**Application no: 22/02693/DISC**

**Location:** Heyford Park, Camp Road, Upper Heyford, Bicester, OX25 5HD

## **Lead Local Flood Authority**

Objection

**DETAILS**  
PHASE 10  
ENGINEERING LAYOUT SHEET 1 OF 3

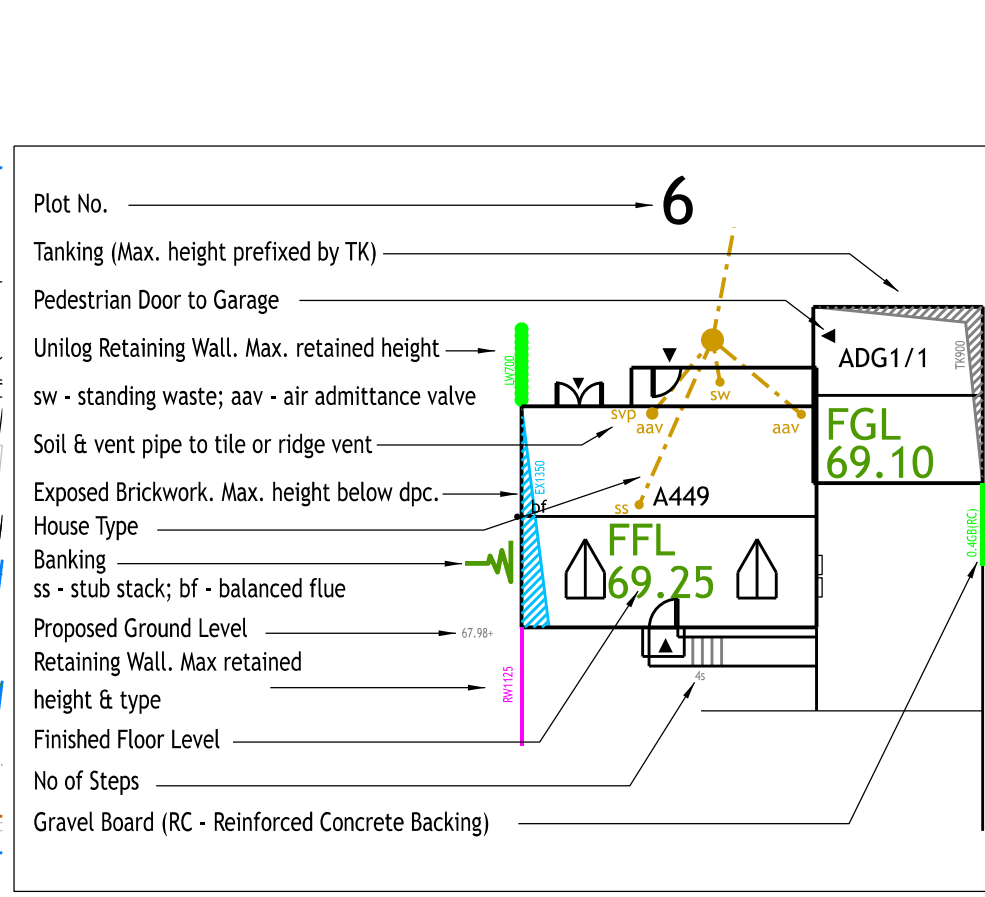
Private areas proposed drainage needs to be shown. At discharge of condition stage all drawings should be detailed and reflect the final design. This is for all infrastructure and SuDS within the phase which the application is referring to.

Permeable not considered at private driveways, at outline stage this was identified as part of the strategy for surface water treatment.
